Our Ref: SSD-77240466

Opal Healthcare Bayview (SSD-77240466)

APPENDIX 1 – Northern Beaches Council advice on additional information – SSD-77240466 - Opal Healthcare Bayview – 36 Cabbage Tree Road, Bayview

PLANTING SCHEDULE AND CHARACTER

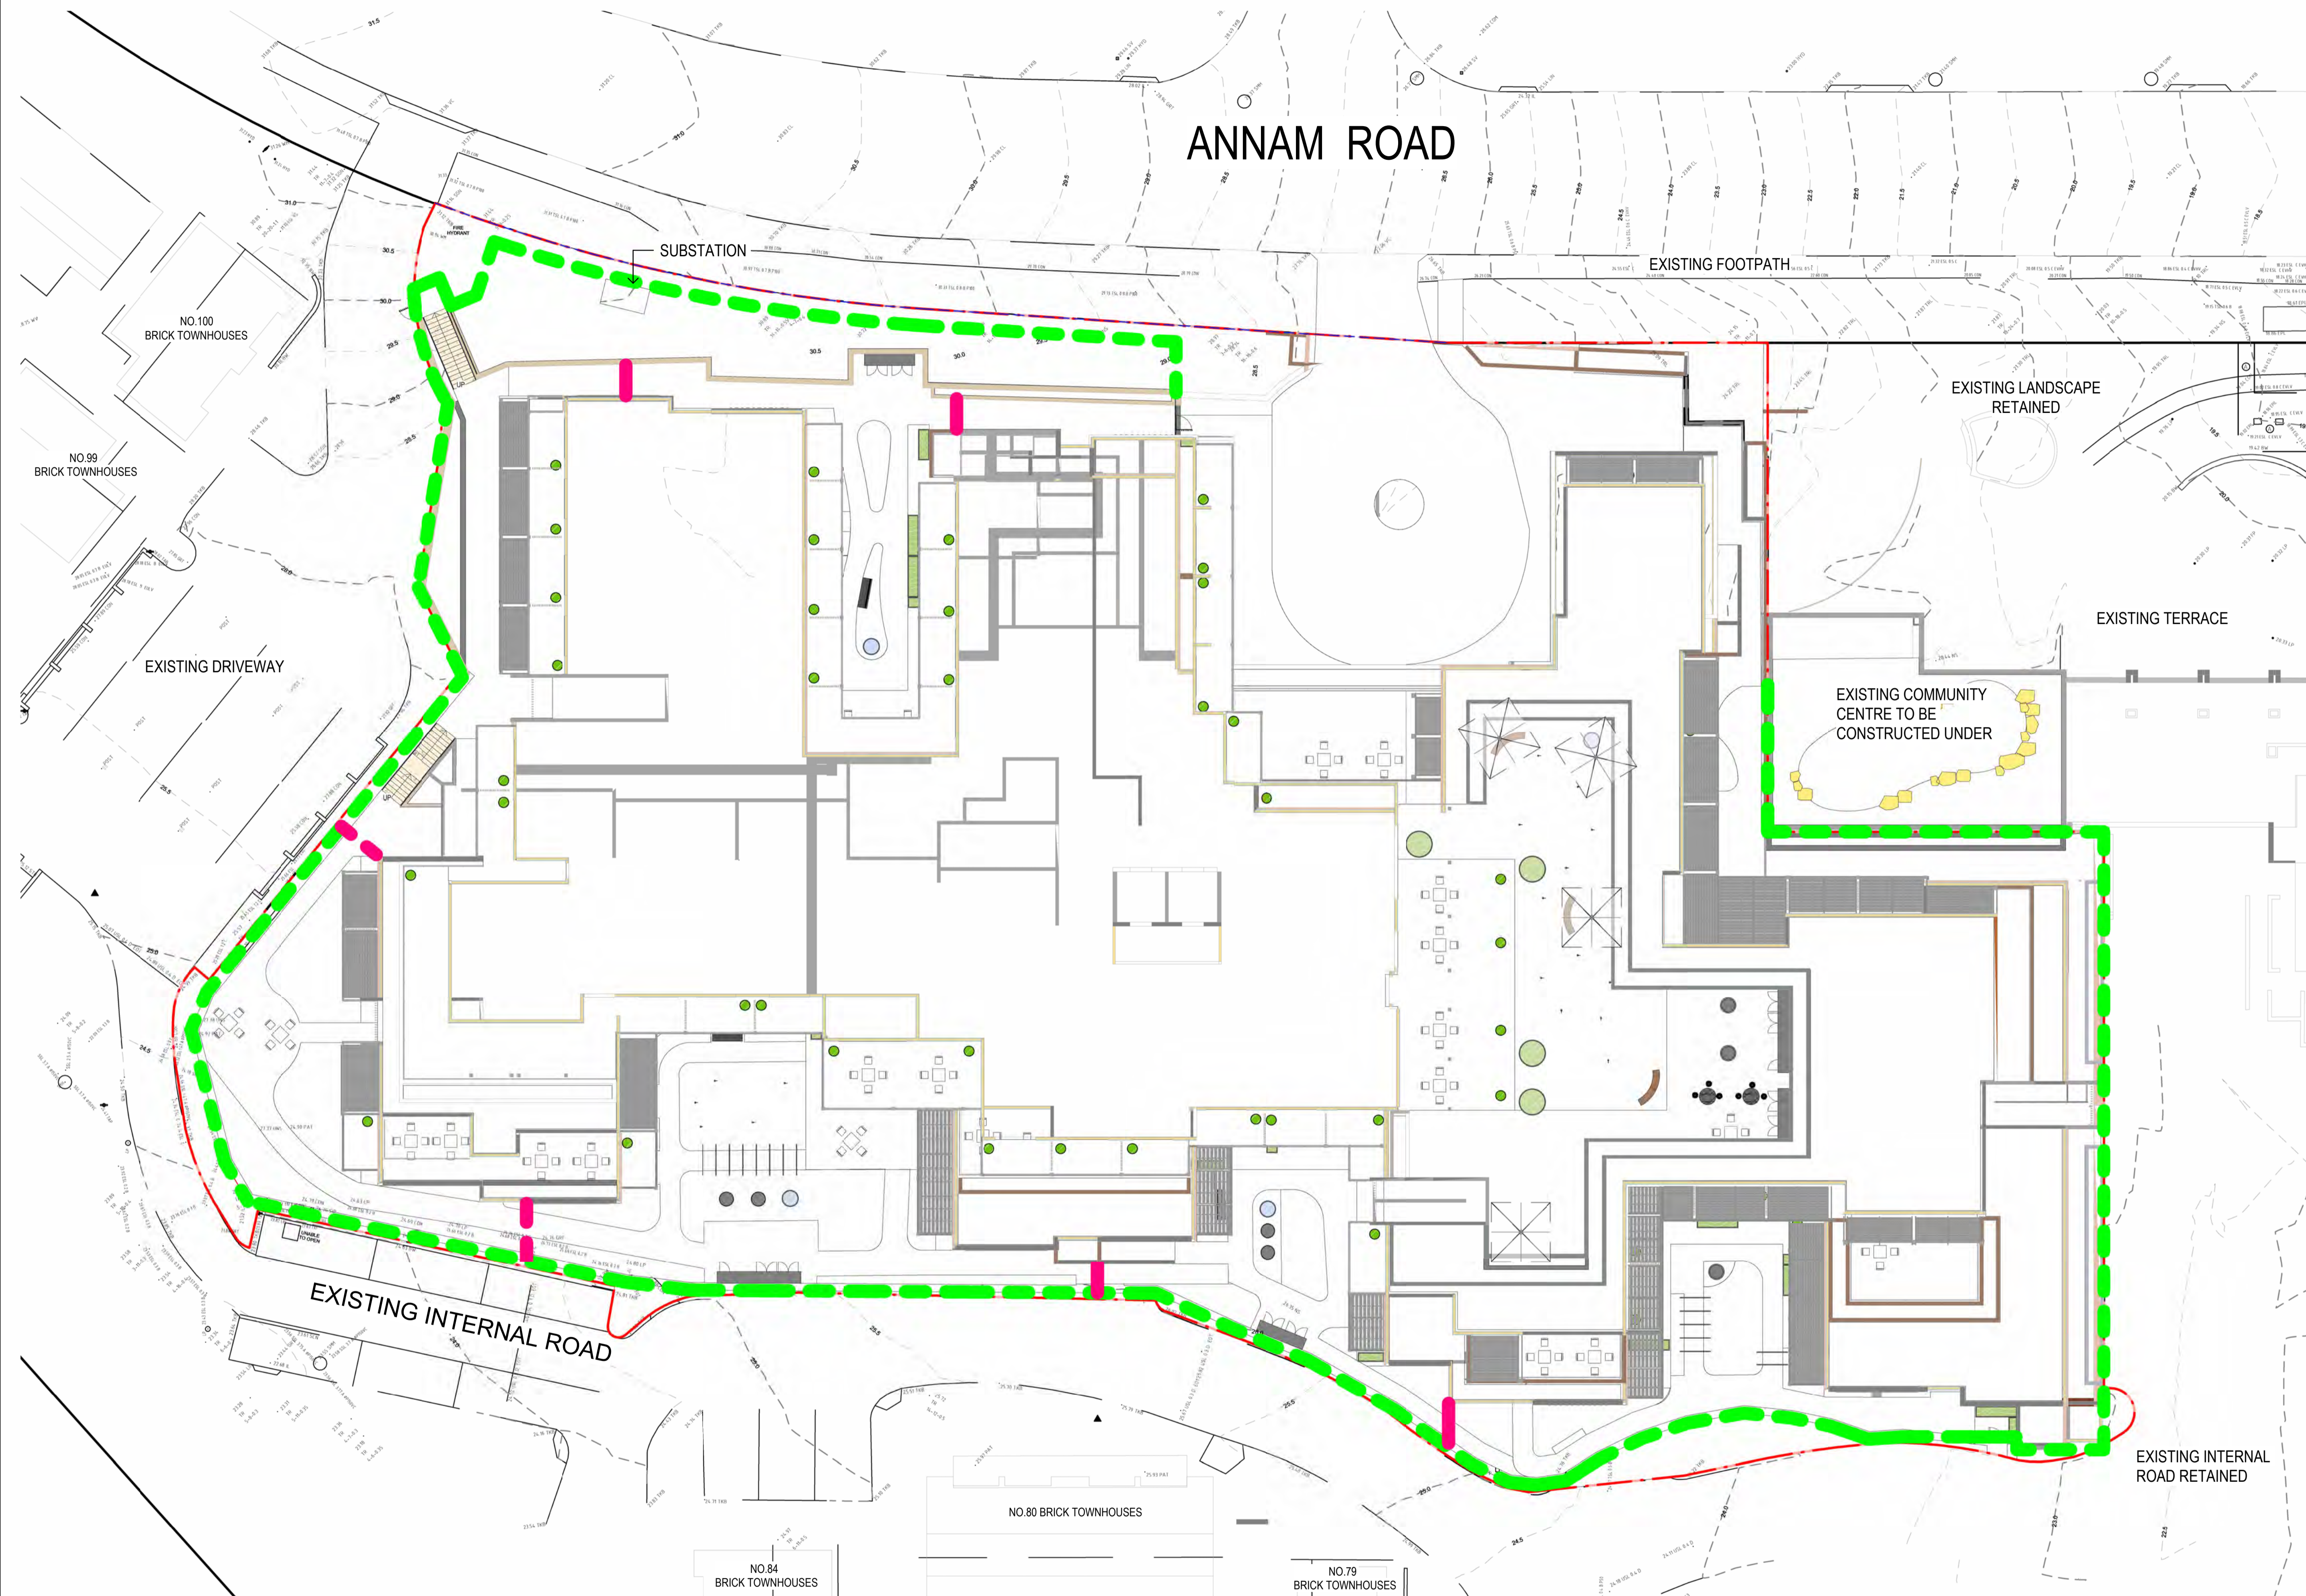
Two species noted in the Landscape plan, *Haloragadendron lucasii* and *Chamaesyce psammogeton* are both Endangered species under the Biodiversity Conservation Act 2016. It is considered unlikely that these species will be available for distribution in nurseries and they are not considered adequate candidate species for the site.
